Fire Marshal Division

**Re: Baker Automotive
280 Medical Drive
Angier, NC 27501**

Application Number FMFW2002-0005

SIZE	DWG #	DWG	REV
		IND FIRE SYSTEM	1
SCALE	N/A	2/10/2020	SHEET 2 OF 9

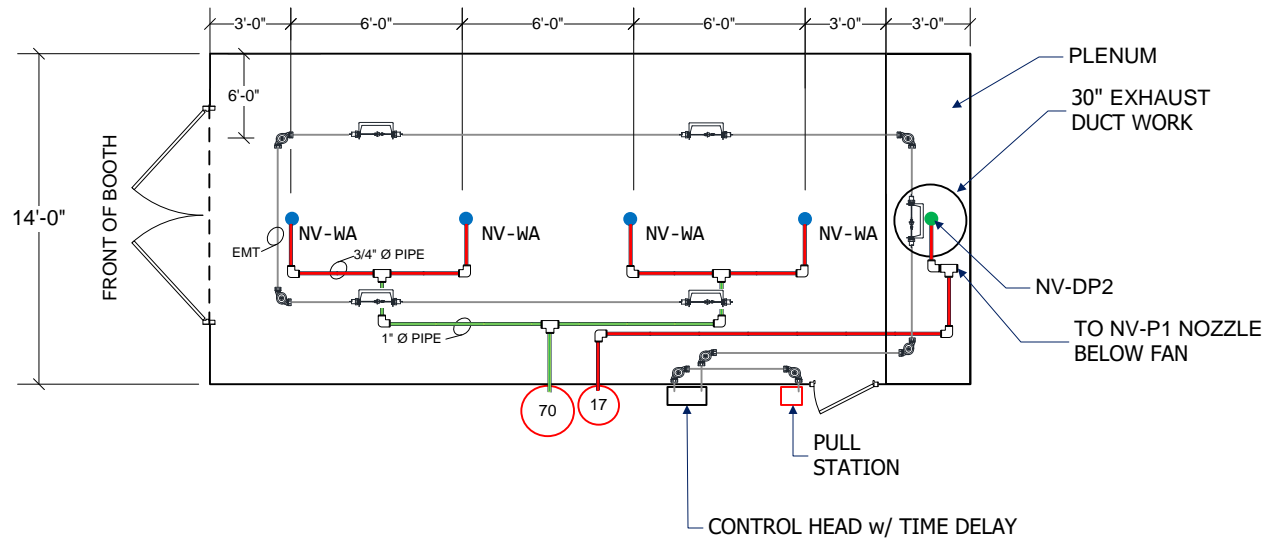
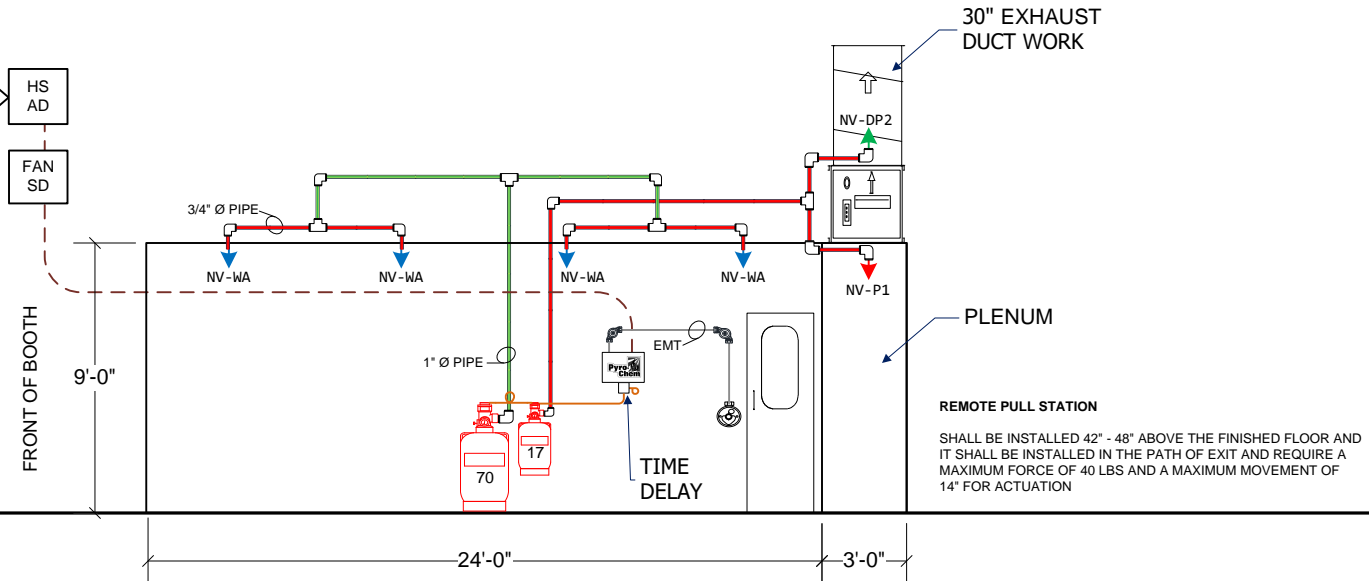
- **Dry-chemical systems.**
 - Dry-chemical extinguishing systems shall be installed, maintained, periodically inspected and tested in accordance with the North Carolina Fire Prevention Code, NFPA 17 and their listing.
- **Ventilation Interlocks**
 - With a total flooding system, the ventilation system for the paint booth is required to shut down before the system operates.
 - Spaying operations **CANNOT** be conducted without the operation of the ventilation system. An interlock must be provided between the ventilation system and spraying operation.
- **Fire Extinguisher**
 - Fire extinguishers of a rating no less than 4A:40 BC shall be within a 30 ft. travel distance from the paint booths.
